**Washington State
Department of Transportation**

September 3, 2014

Subject: BL-14-00012 – Spirit Wind Farm
SR 90 milepost 97.35 right

We have reviewed the proposed boundary line adjustment and have the following comments.

BOUNDARY LINE ADJUSTMENT		
PREPARED FOR		
FRANK RAGLAND		
A PORTION OF THE EAST 1/2 OF SECTION 5,		
TOWNSHIP 18 N., RANGE 17 E., W.M.		
KITITAS COUNTY	WASHINGTON	
DWN BY	DATE	JOB NO.
G. WEISER	05/2015	045881
CHKD BY	SCALE	SHEET
D. PIERCE	1"=200'	1 OF 1

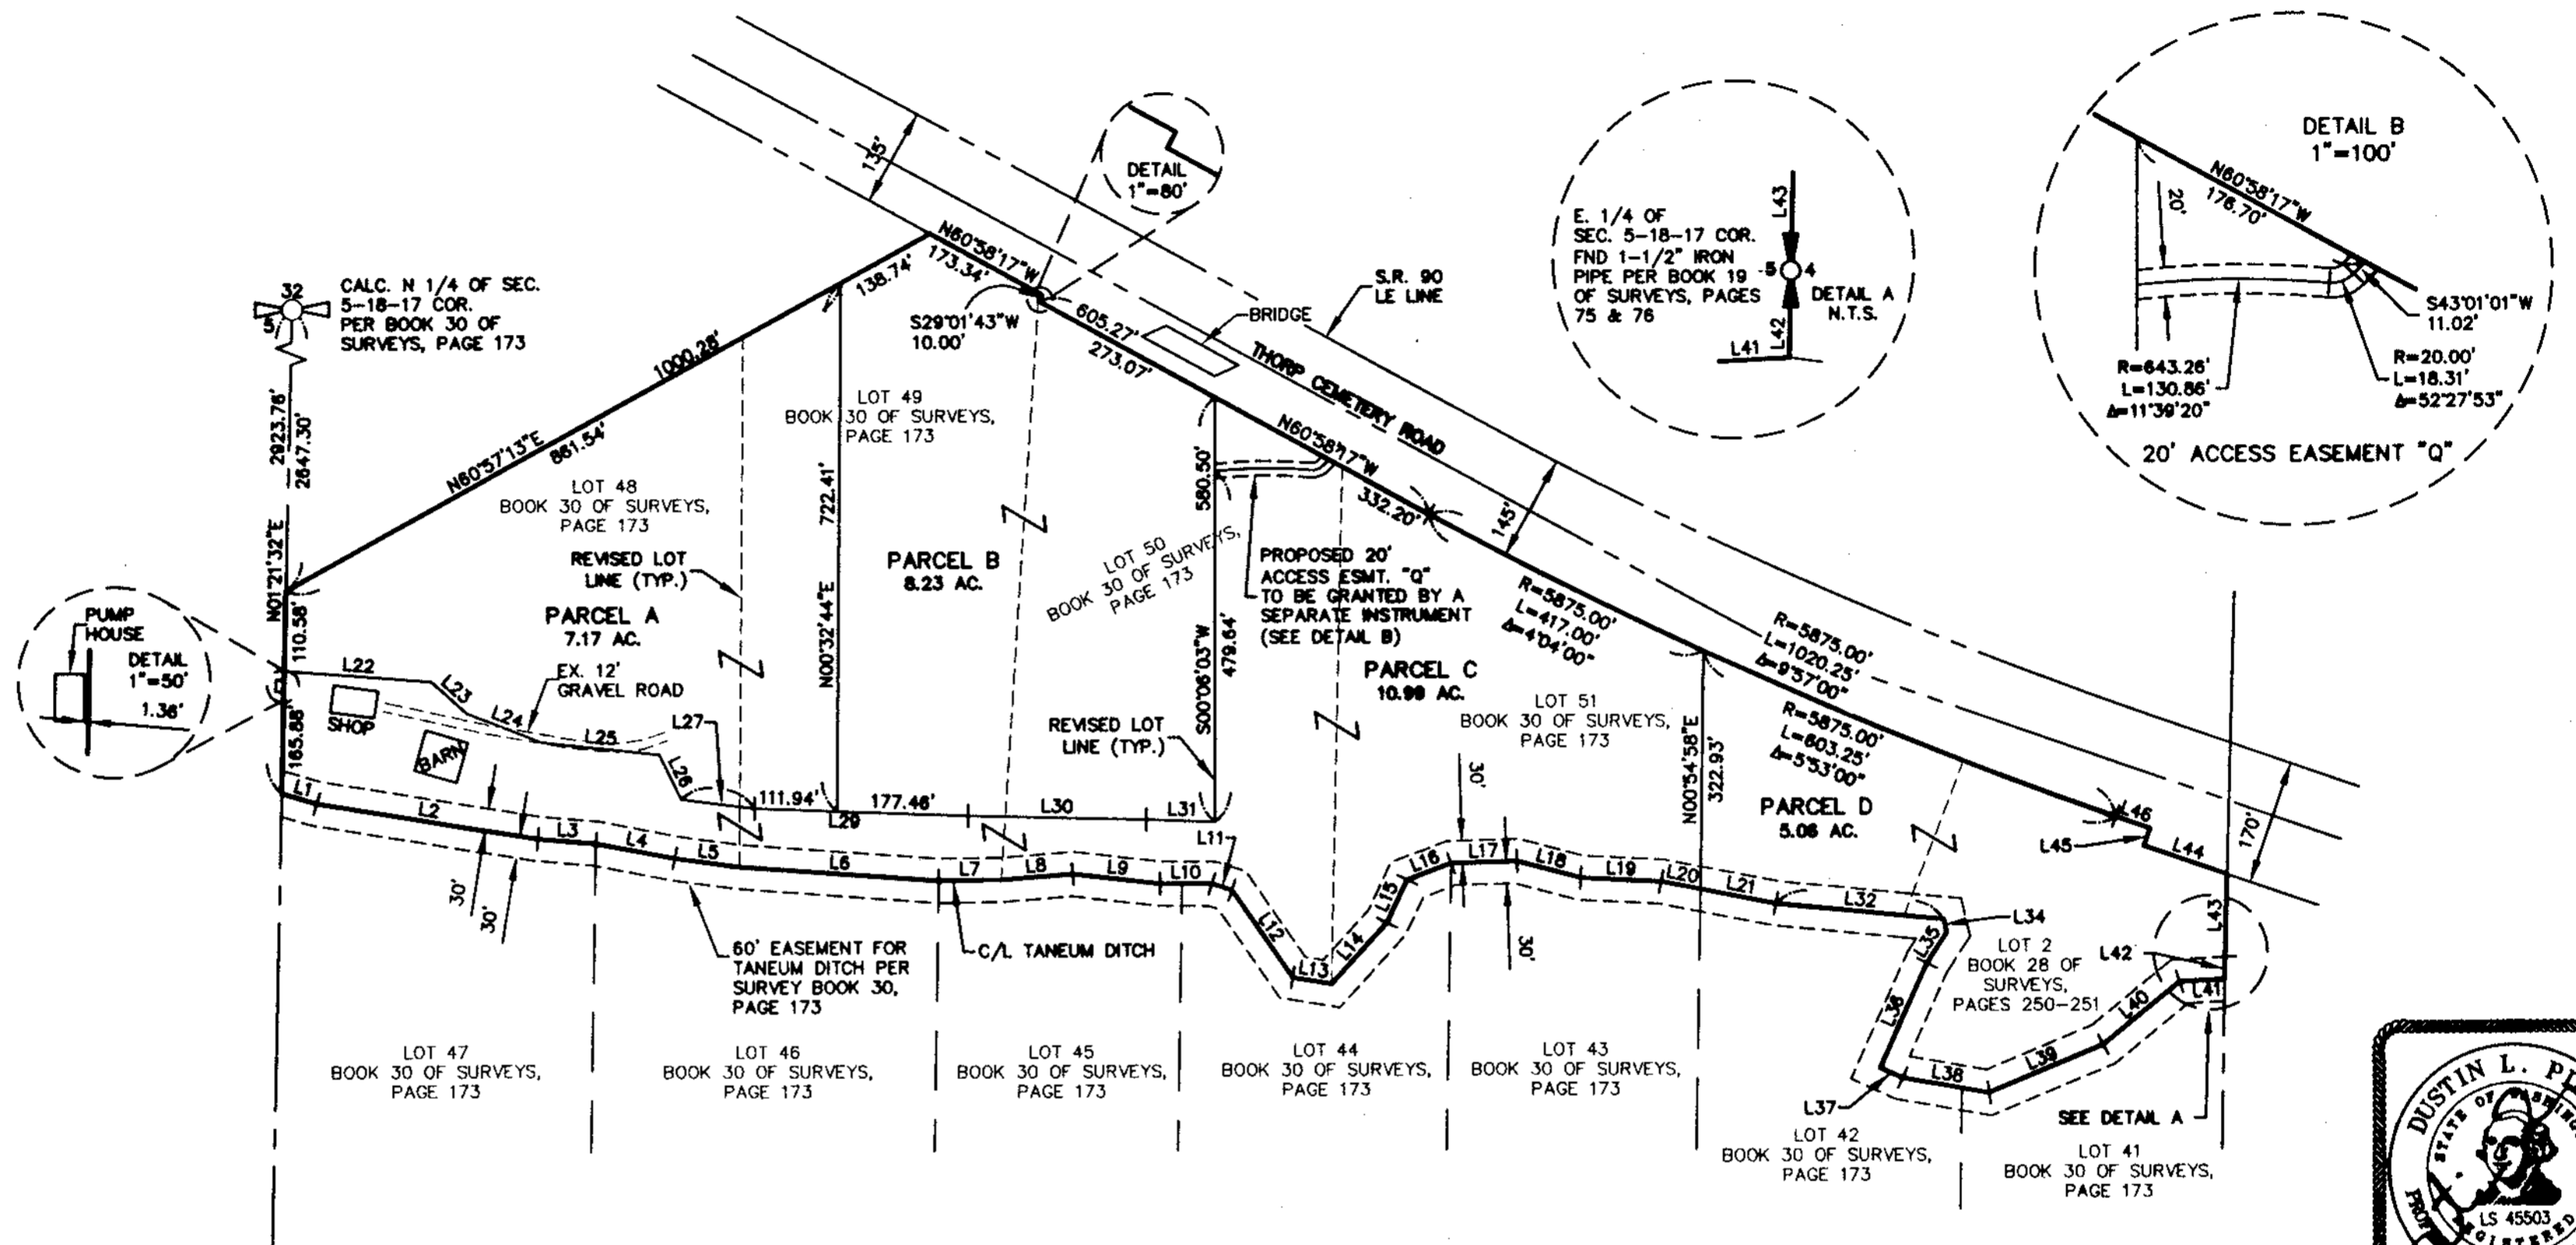
- The subject properties are adjacent to Interstate 90 (I-90), a fully-controlled limited access facility with a posted speed limit of 70 miles per hour. WSDOT has acquired all access rights to the highway. Direct access is prohibited.
- Our records indicate a channel change easement exists within the northern half of Parcel B (see attached right-of-way plan *SR 90 Yakima River to West Side Canal sheets 22 & 23 of 29*). Any future development must not encumber the WSDOT's ability to maintain this portion of Taneum Creek.
- Stormwater and surface runoff generated from these properties must be retained and treated on site and not allowed to flow onto WSDOT rights-of-way.
